BUILDING PERMIT

Located At 127 MARGINAL WAY

Marge Schmuckal - RE: Walgreens - 127 Marginal Way - Portland, ME - Tower (Window) Sign - Plan Review Status

RE: Walgreen's – Tower Sign

1a PART. ELEV.
A2.1 SCALE: 1/8"=1'-0"

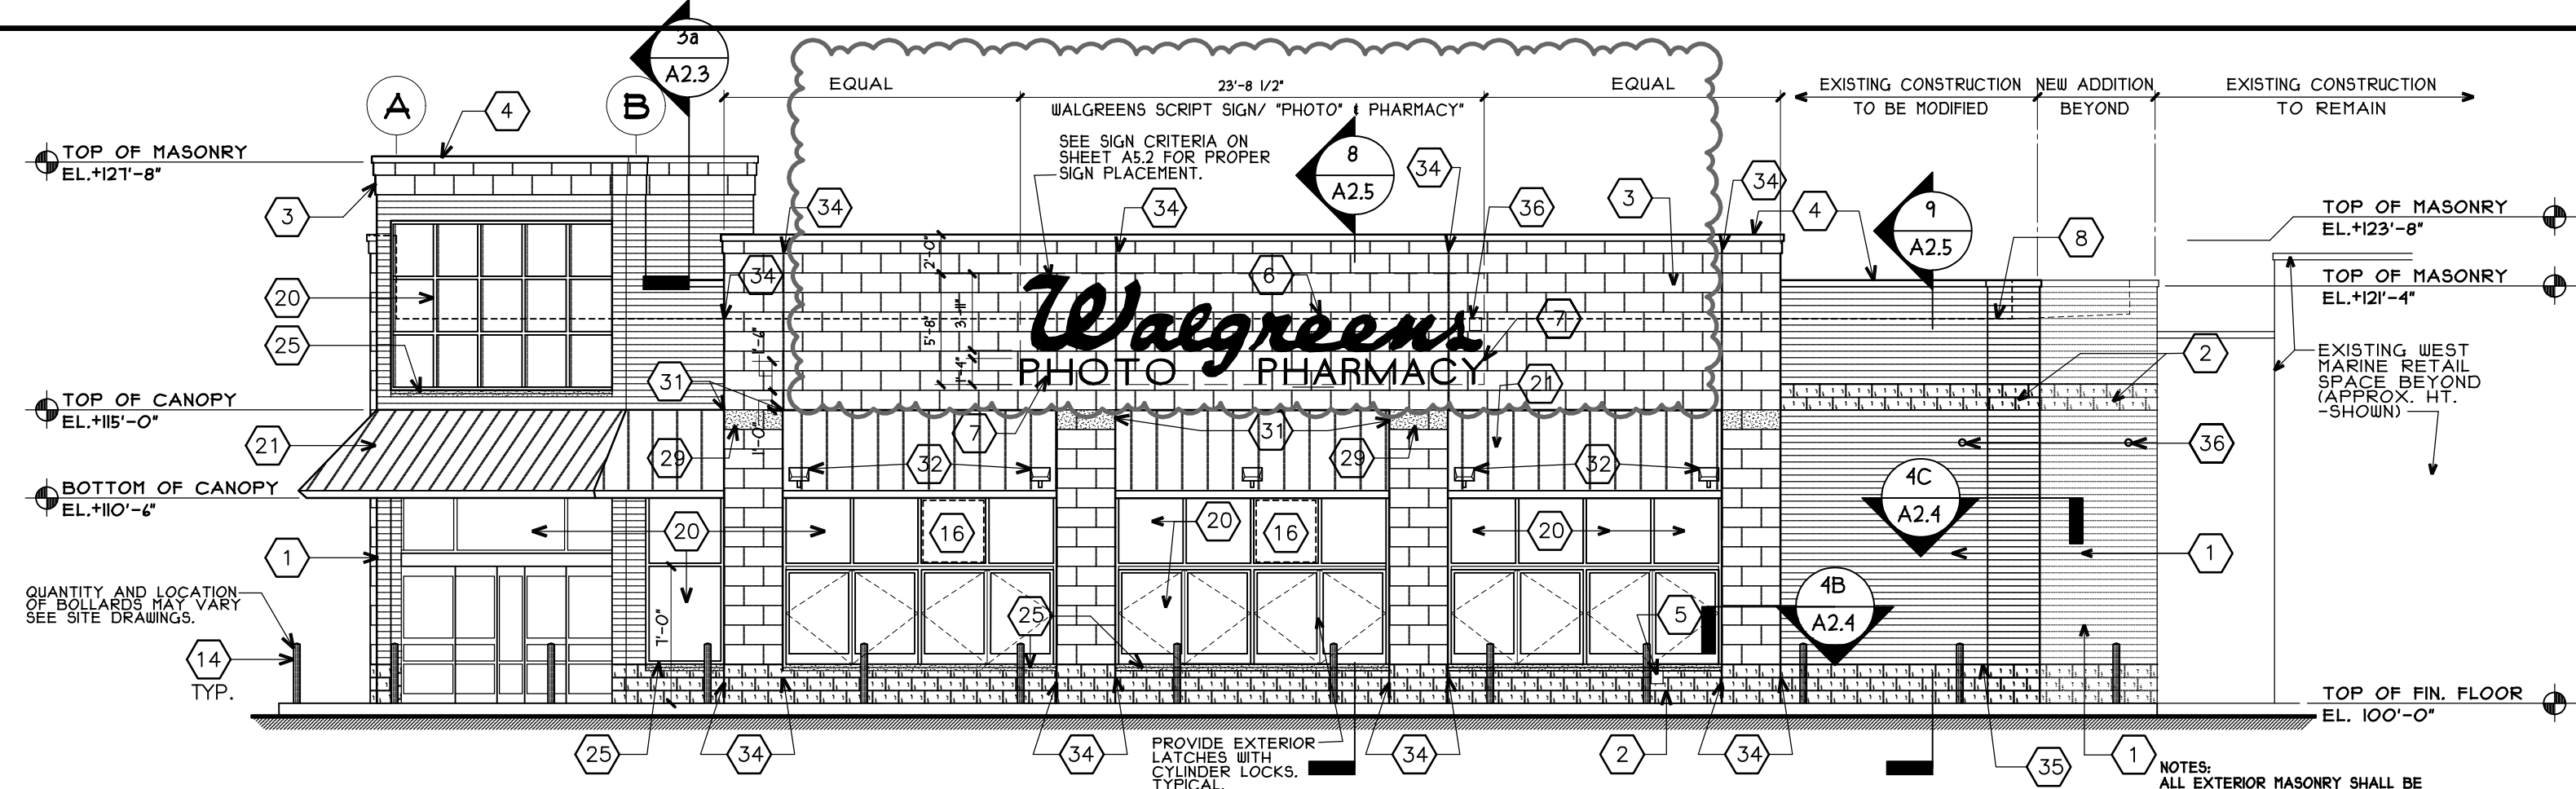
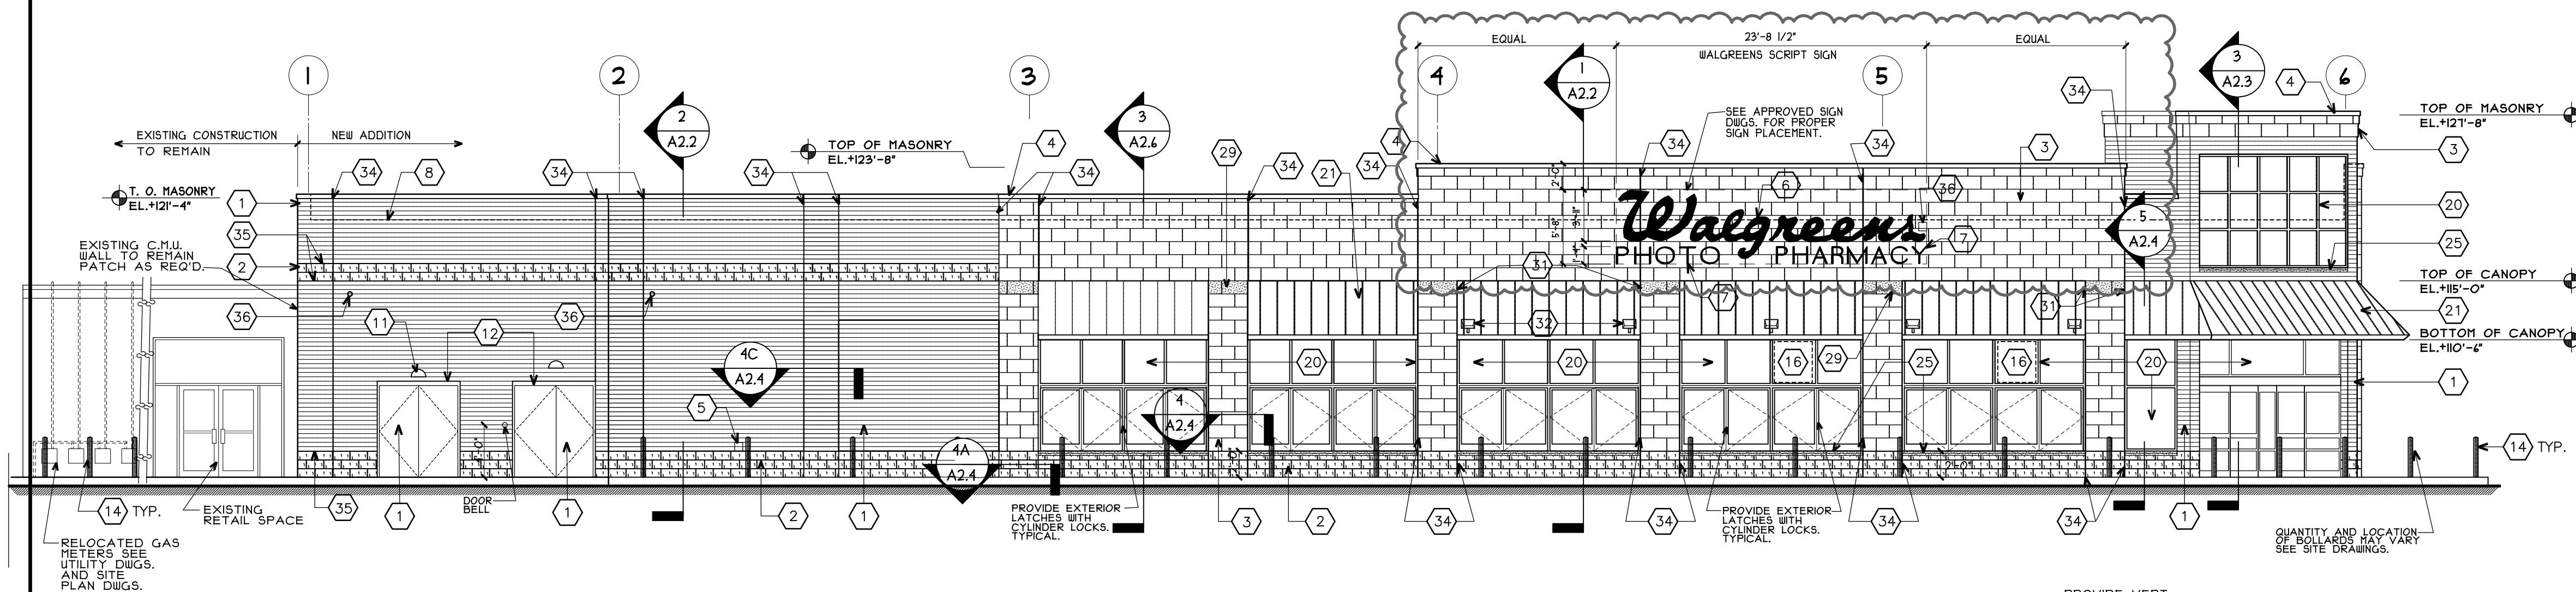
I do have a question tho. On sheet A2.1 there are two drawings for the tower window. You highlighted the upper partial elevation. However, just below that partial tower elevation is another elevation with different window dimensions. Which window dimension is truly what was built?
Marge
